CITY OF ALBUQUERQUE

Planning Department Transportation Development Services Section

Re: Certification Submittal for Second Temporary Building Certificate of Occupancy
(C.O.) for Corrales Shopping Center Expansion Phase II, [A-14 / D001B]
10701 Corrales Road NW
Architect's Stamp Dated 04/07/10

ADMINISTRATIVE AMENDMENT SITE PLAN

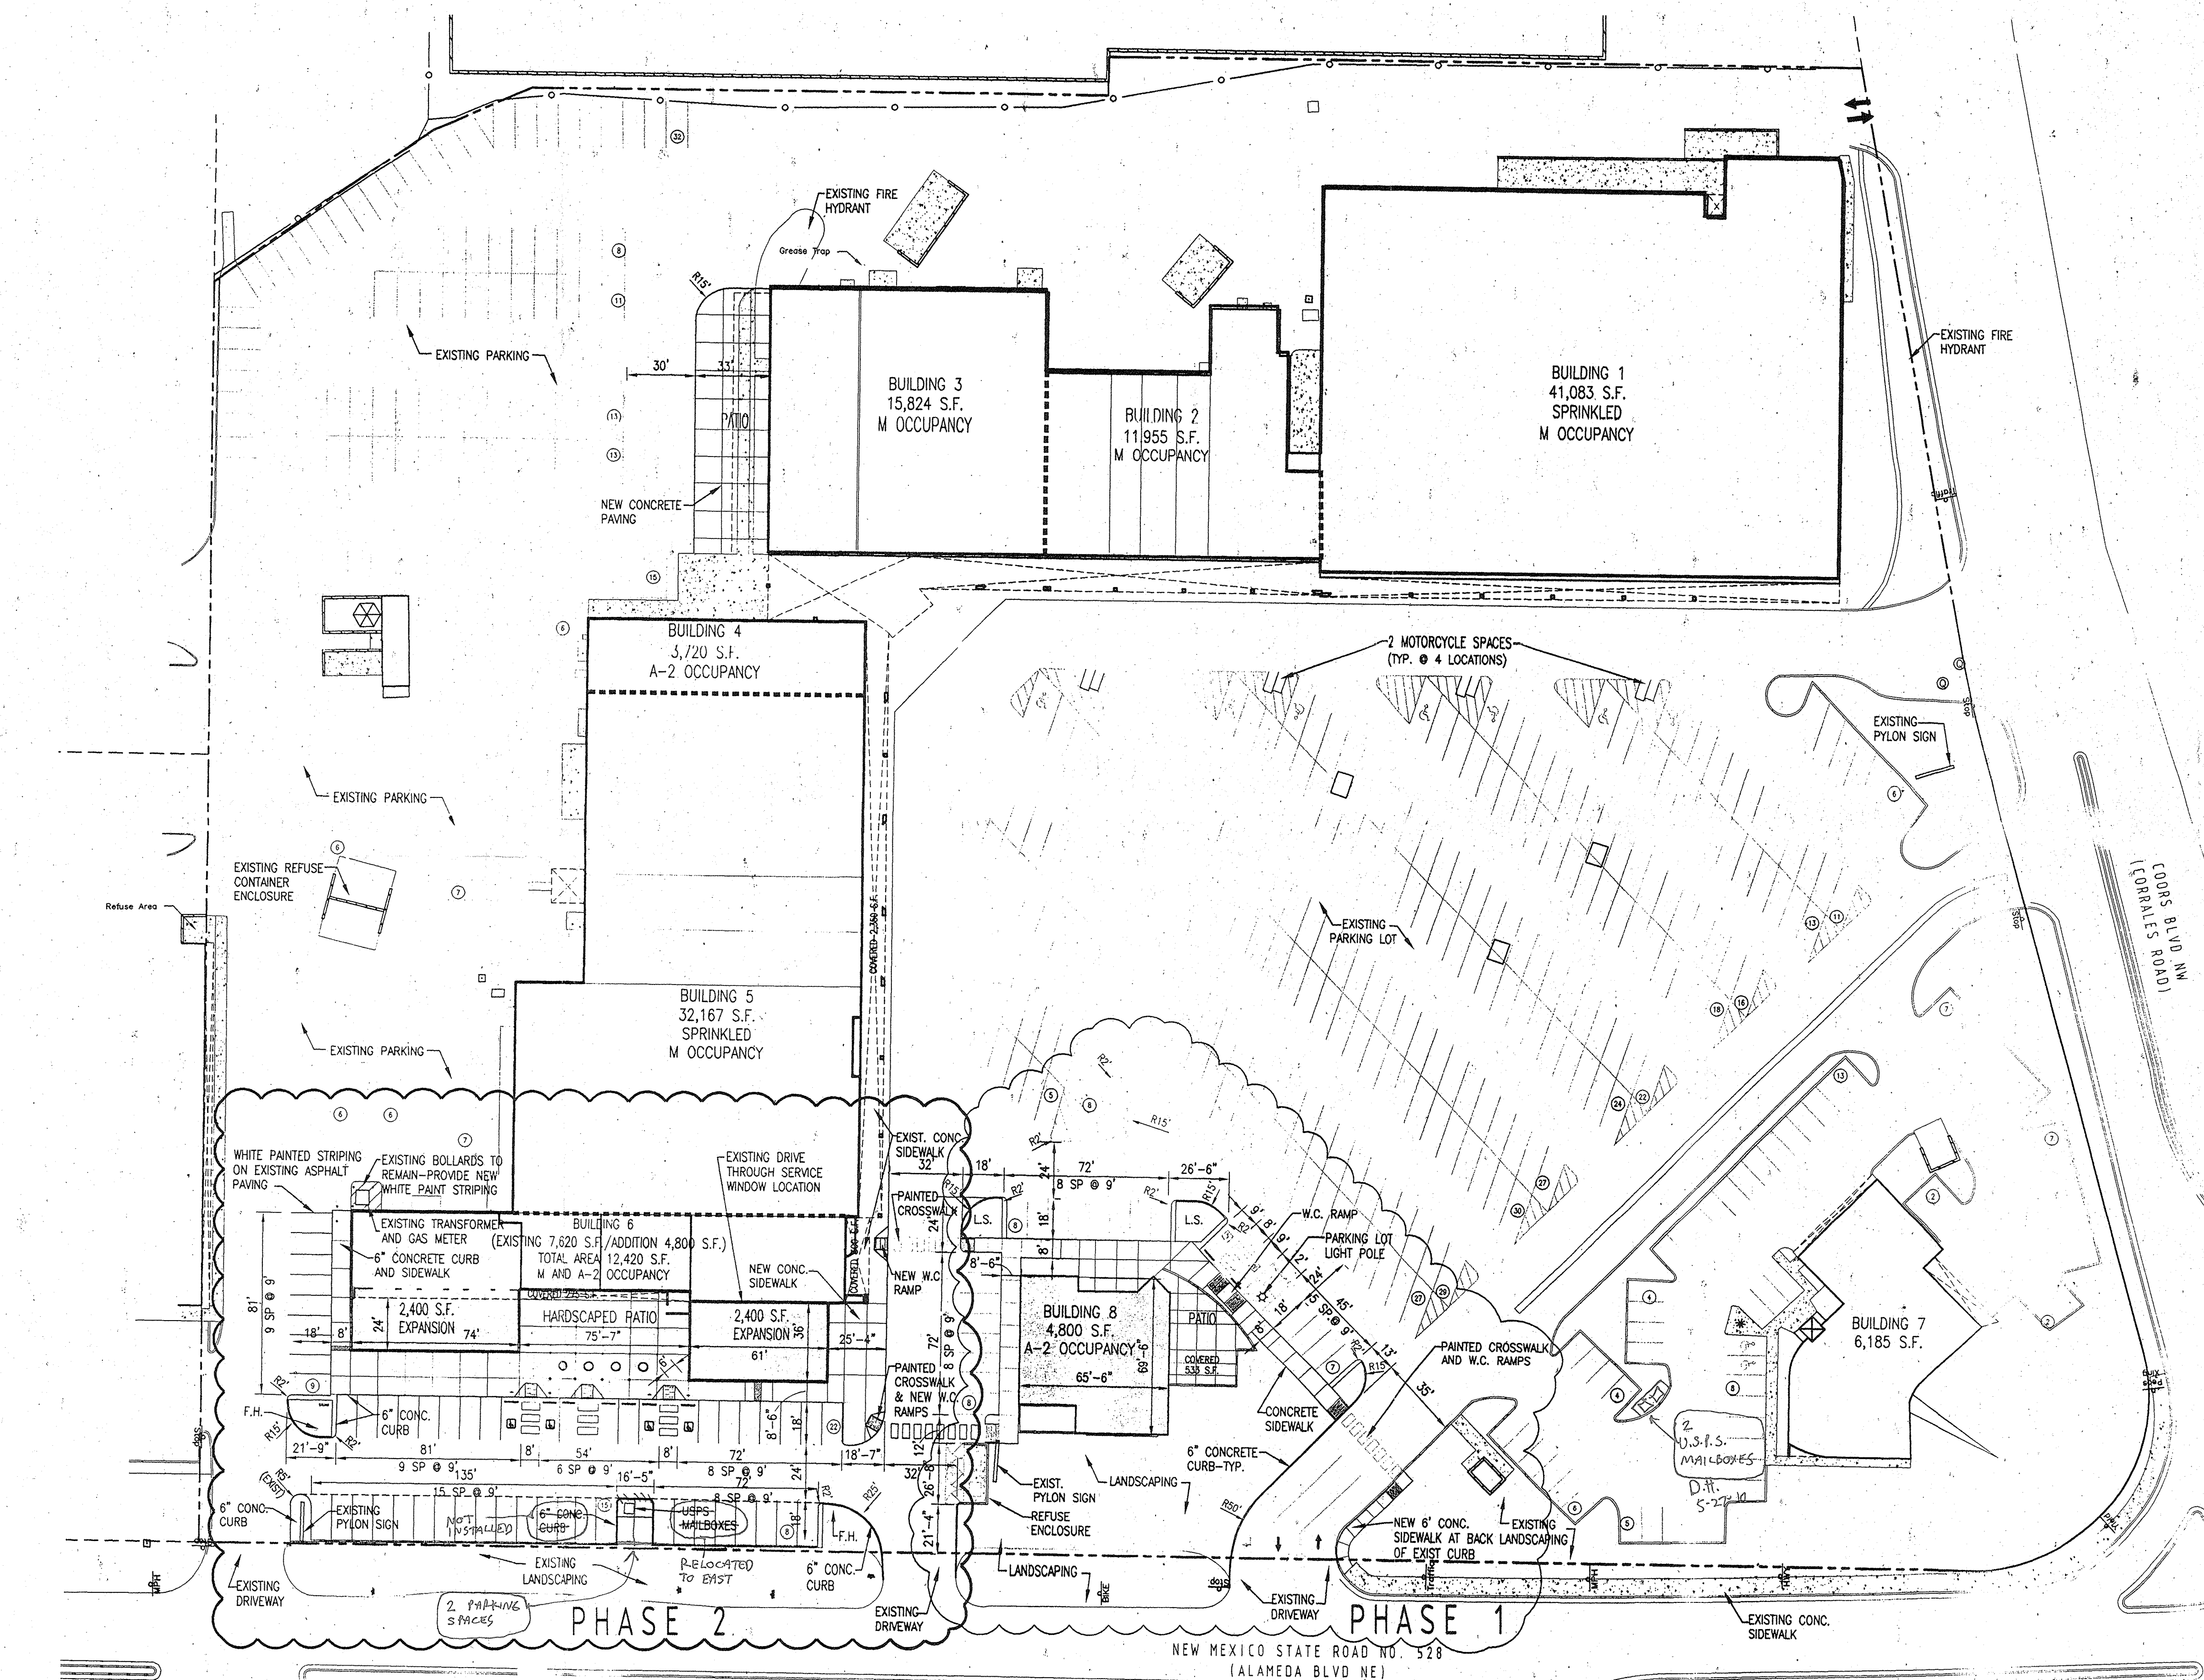
The following items will need to be addressed prior to issuance of a Permanent Certificate of Occupancy: Existing location of USPS Mailboxes – you have two angle irons sticking out of ground (see attached pictures) on parking stall (asphalt patch will be needed on this segment of stall) and mailboxes haven't been relocated to new location as shown on Site Plan. Once these issues have been addressed you'll need to re-submit for a Permanent C.O.
